Christina Stacey - RE: Permit #2923 - 1125 Brighton Ave (Loring House)

Thank you for the additional information. The proposed changes for the Loring House do not trigger site plan review. All of the work can be handled through the building permit process.

Wright-Ryan has been hired by Wishrock to be the CM at Risk for a renovation project at 1125 Brighton Ave. We have submitted for a Building Permit - #2923. I have copied Penn Lindsay – VP at Wishrock - and Phil Renzi – the Architect on this email so that they can participate in this conversation.

A0.01

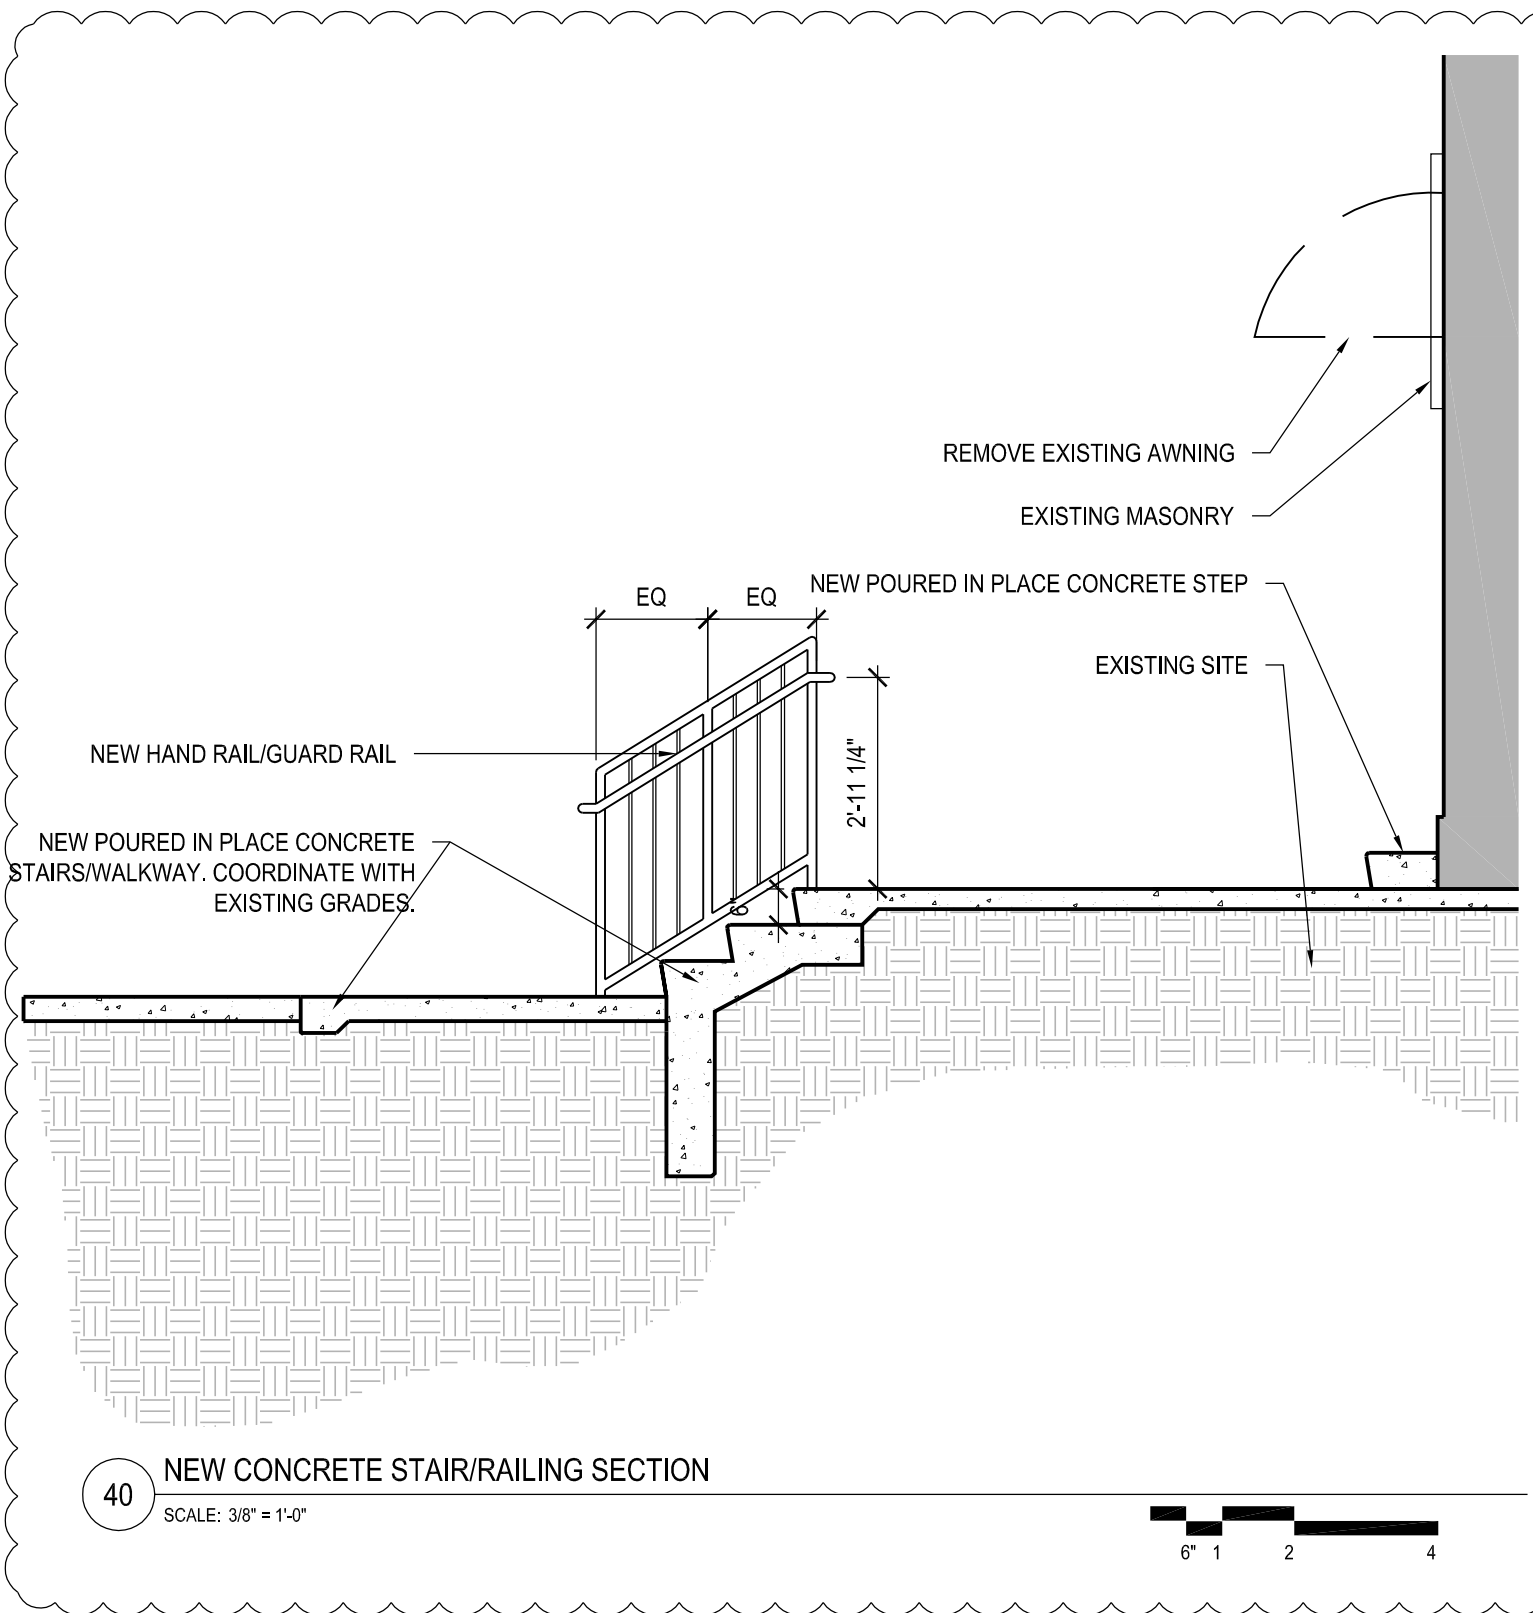
There is a note that the areas will be graded to pitch away from the buildings. Do you have the proposed grades that can be layered over the existing grades?

Hi Barbara: The note is really meant to ensure that positive drainage away from the facades is maintained, or where needed, provided, we are not planning on changing the grades. Given the small elevational difference between the invert of the catch basin inlets and the sills of the existing windows we cannot re-grade.

Sheet Name:  
**Grading & Drainage Plan**

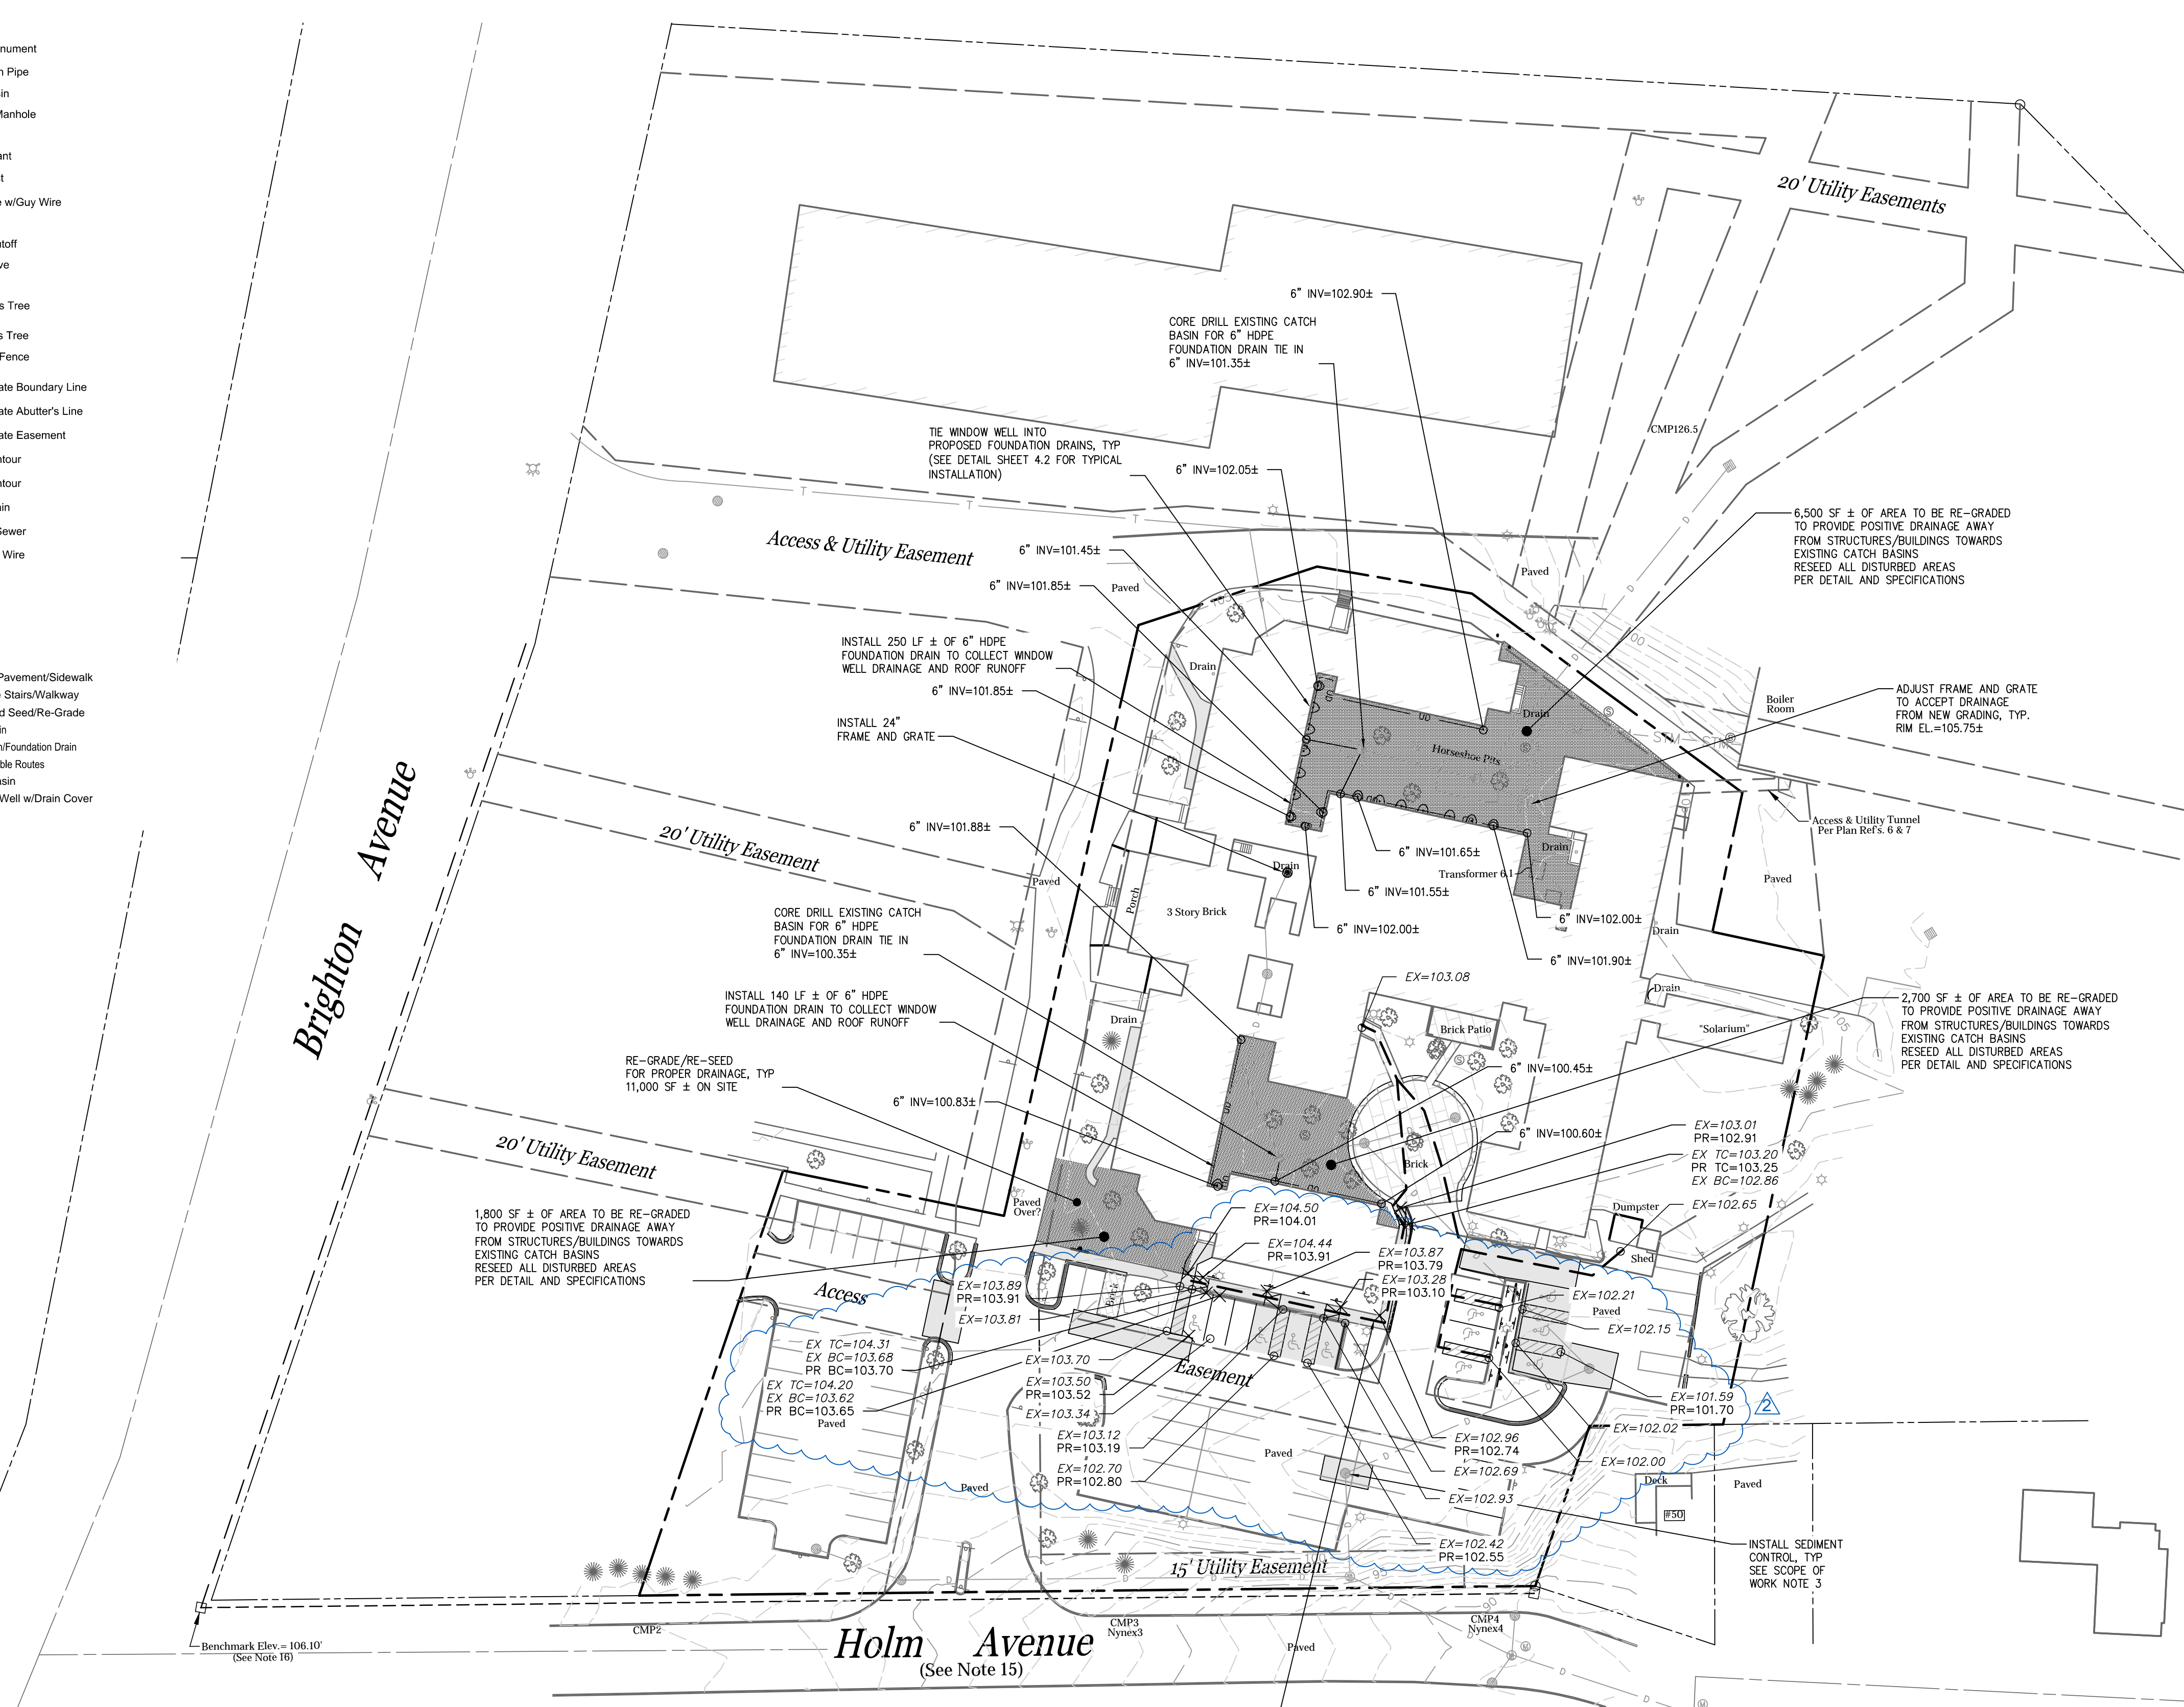
I received your voice message and e-mail today. I have looked at the site plan and the grading plan. I did not see an existing conditions plan, so I would like to better understand the scope of changes before advising whether a site plan review is triggered.

There are notes that certain areas will be graded to achieve positive drainage to catch basins. Are you adding any new catch basins or storm water infrastructure? **TAT Response: No new catch basins or storm water infrastructure are planned. We are extending 6" HDPE foundation drains from new window wells to existing catch basins as indicated on drawing C3.1** Do you have a plan that shows the contours or spot elevations? **TAT Response: Drawing C3.1 Grading and Drainage Plan (submitted as C3 Grading & Drainage) indicates existing grades in the background of the drawing.**

There is a note about resurfacing parking areas. Are you adding any new impervious areas and if so, how much is being added? **TAT Response: No new impervious areas are being added.**
